# Sign Plan\_V2.pdf Markup Summary

# VENETUCCI FARMS

A PORTION OF THE SW  $\frac{1}{4}$  OF THE SW  $\frac{1}{4}$  OF SECTION 11 AND A PORTION OF THE NW  $\frac{1}{4}$  OF SECTION 14, EL PASO, COUNTY  
 5202 HWY 85-87, 5210 HWY 85-87, 5304 HWY 85-87 & 5304 HWY 85  
 SPECIAL USE PERMIT - BUSINESS EVENT CENTER

**SIGN PLAN**

**SIGN PLAN**  
**4**  
 4 OF 9  
 PPR 21-053  
 AL 21-015

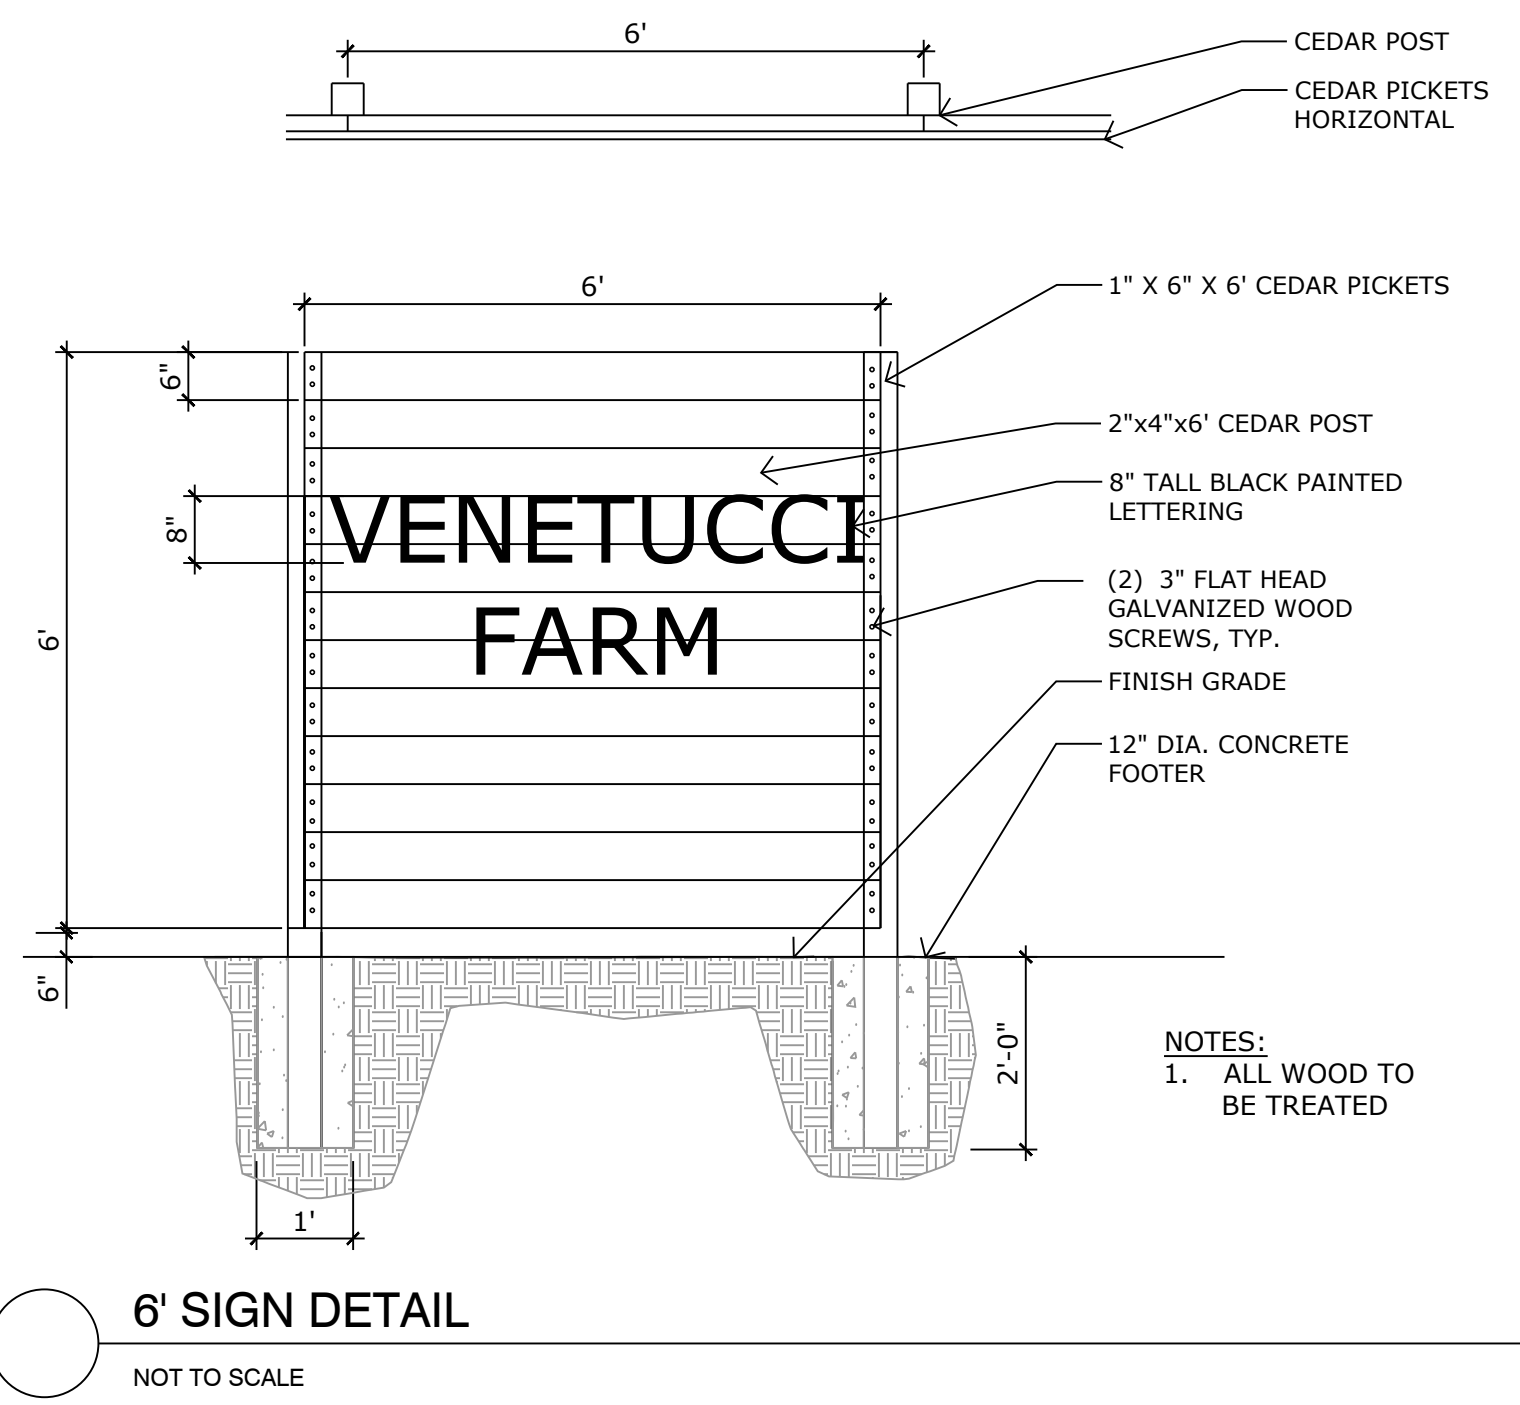
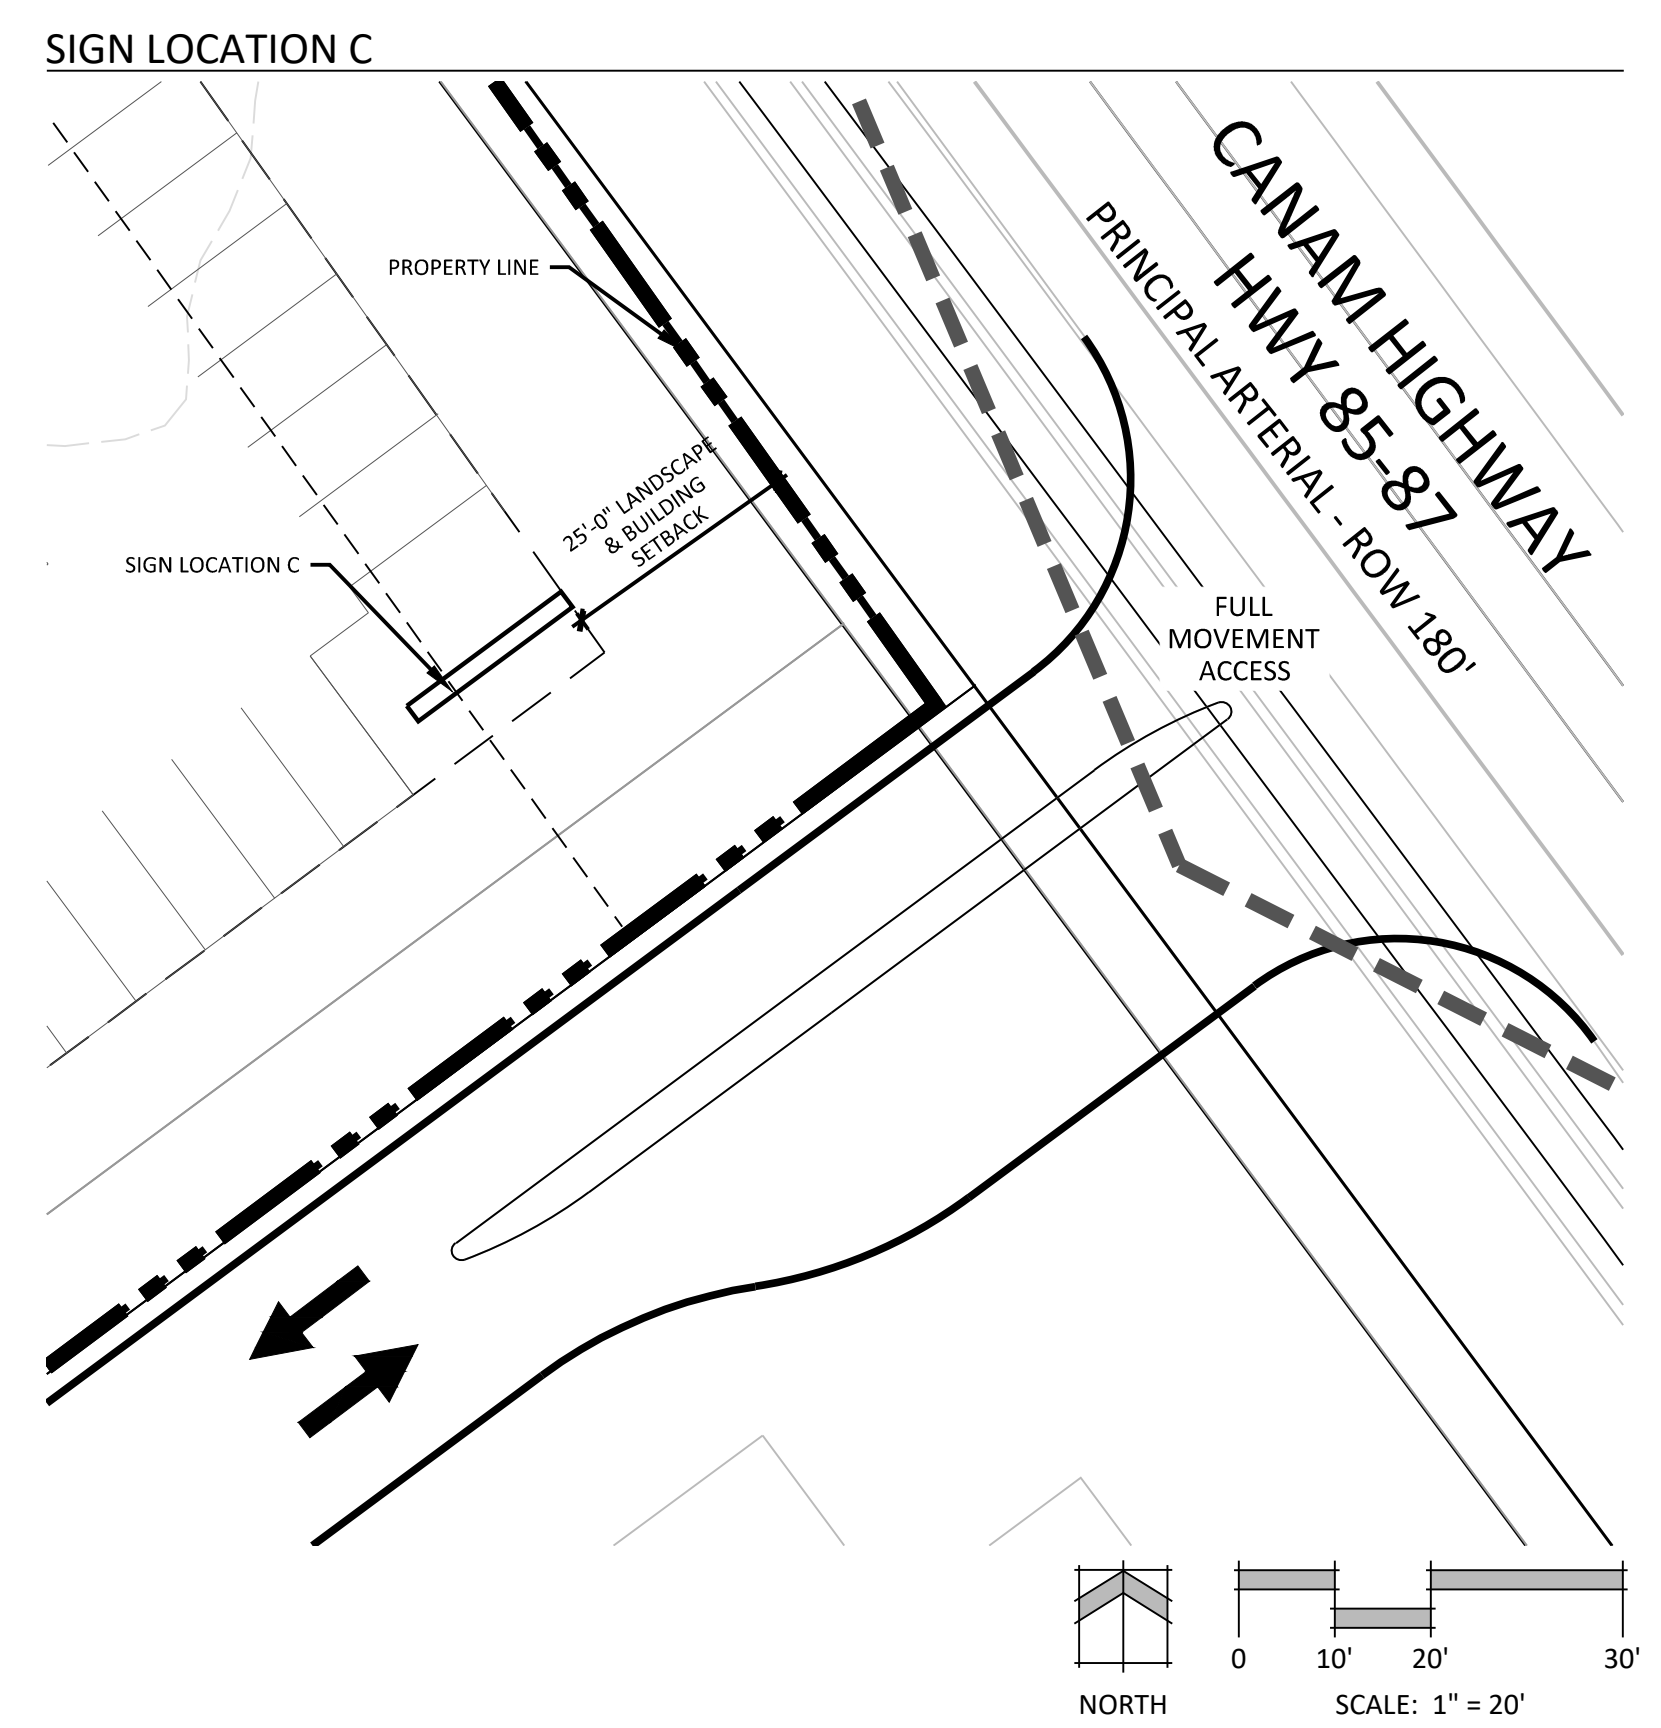
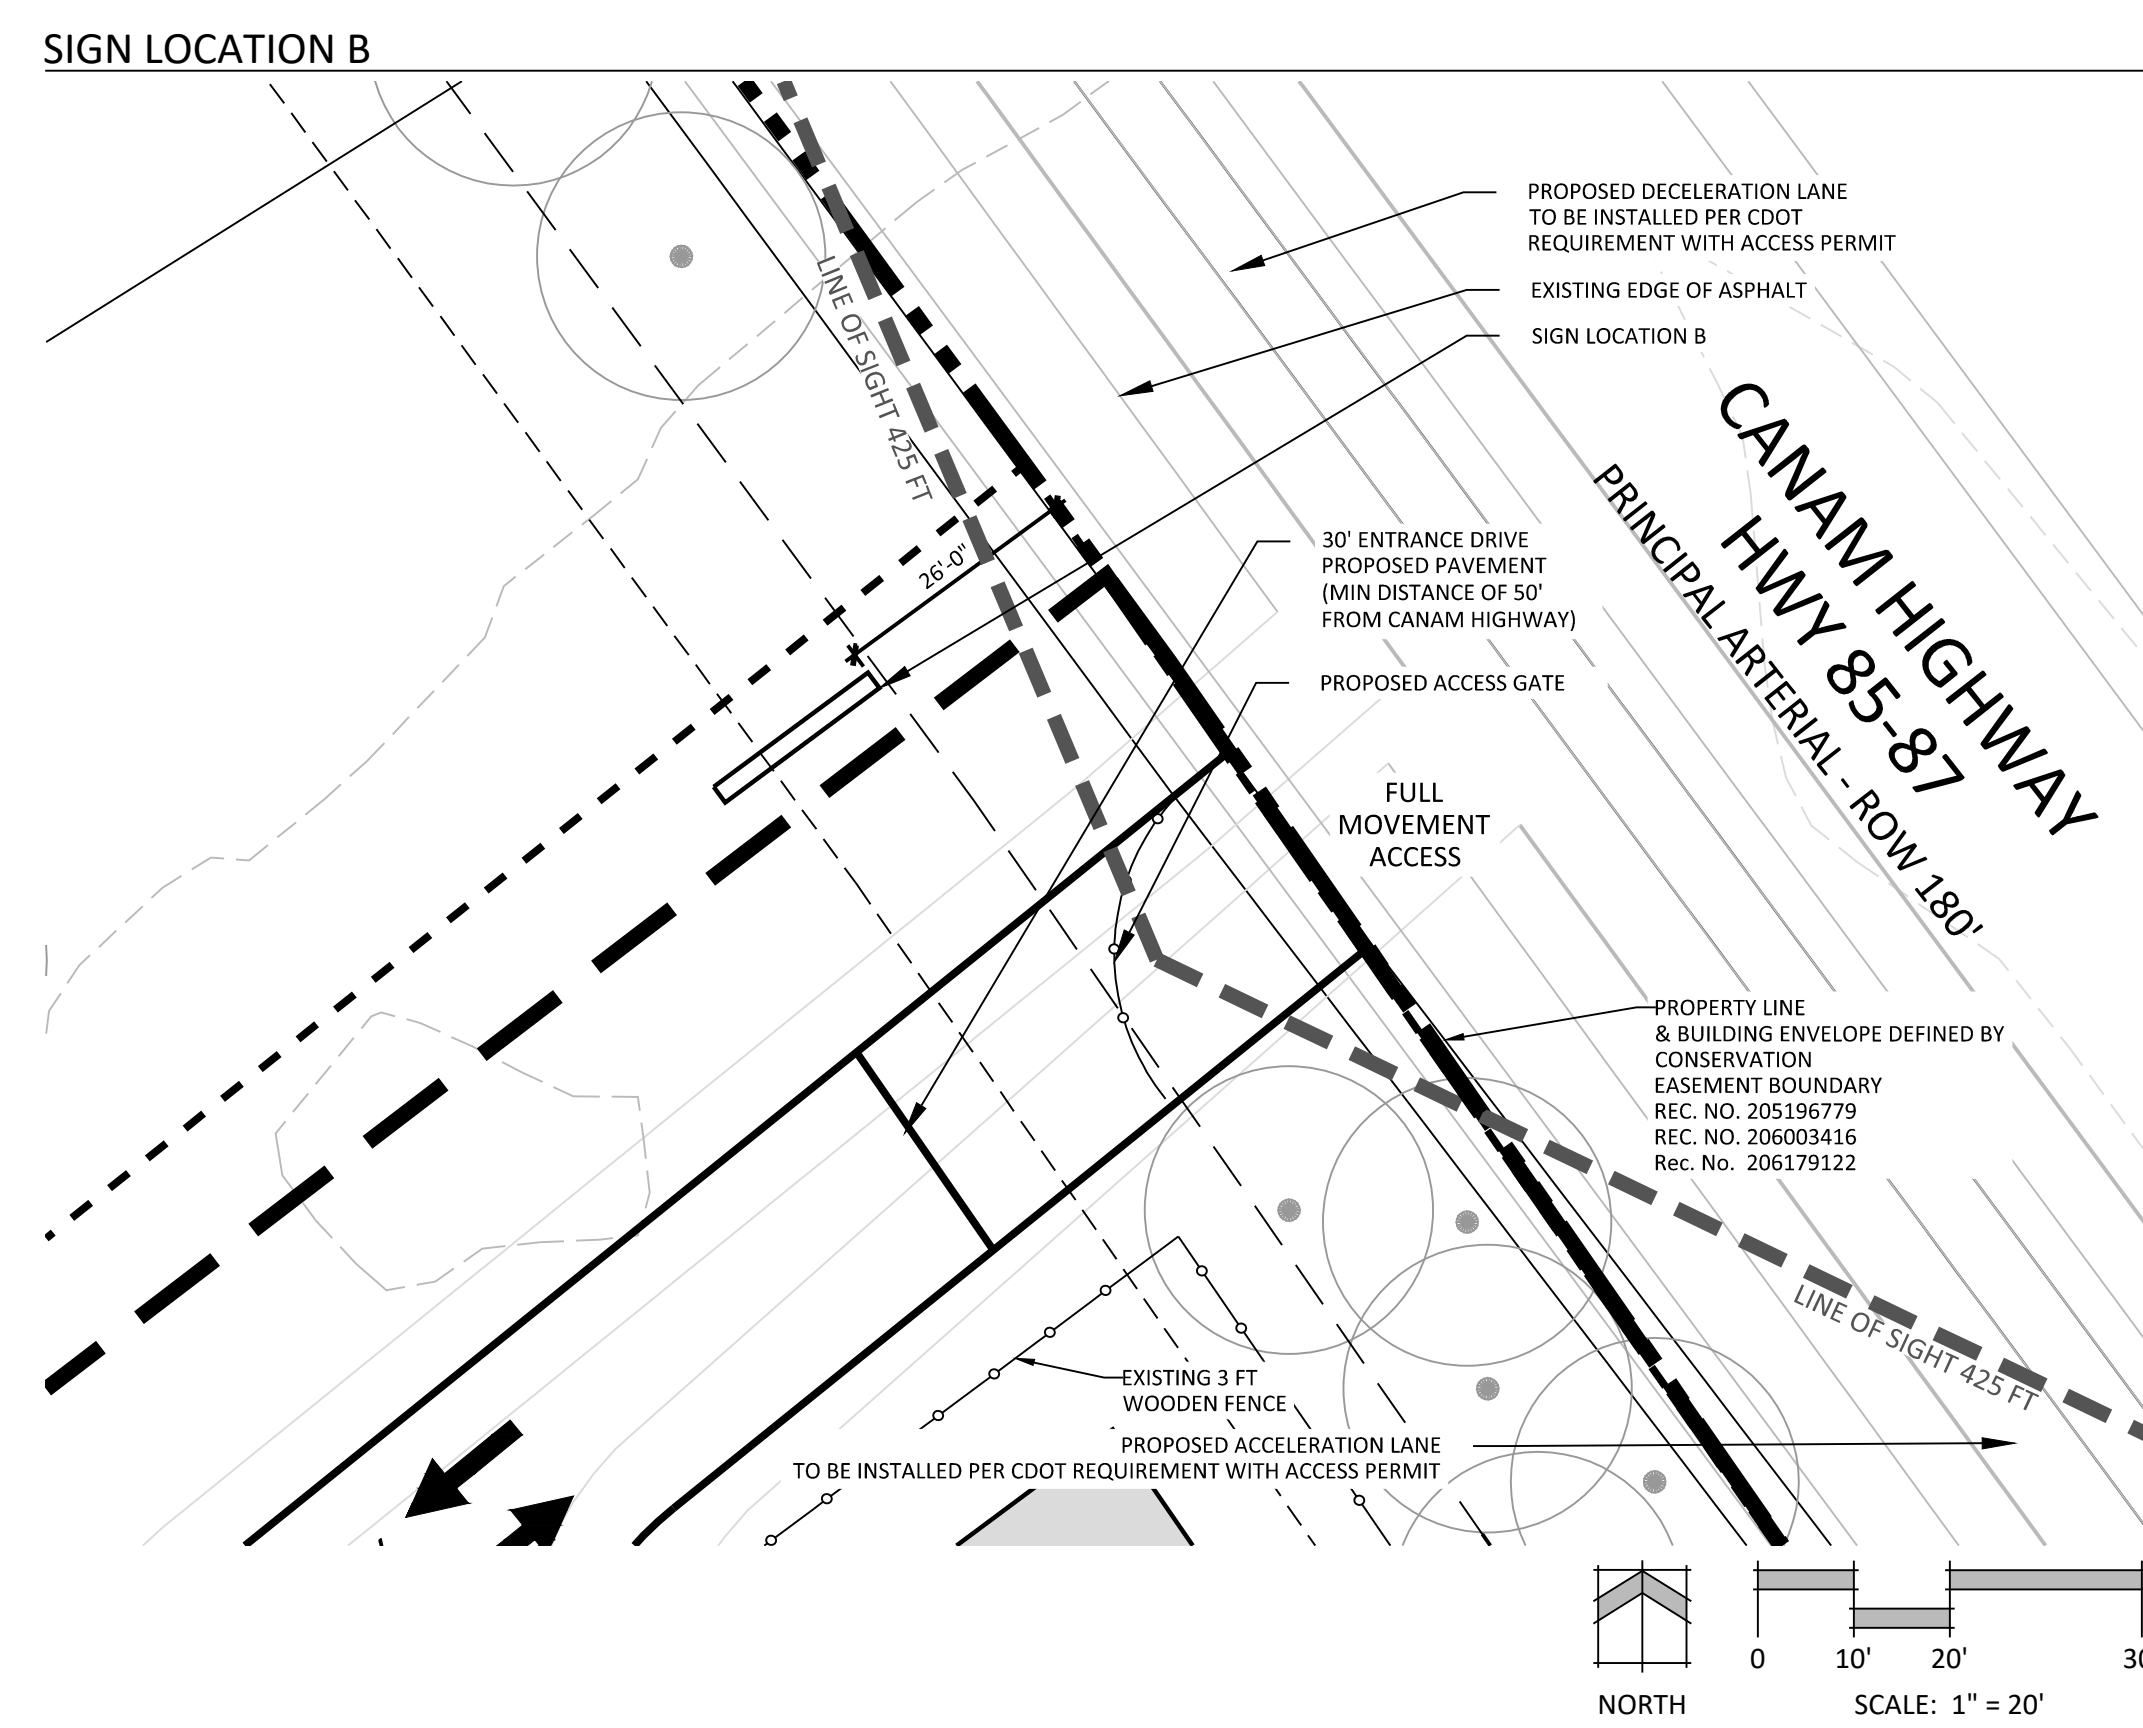
Include summary of square footage of the total allowed signage and existing and proposed signage for the property
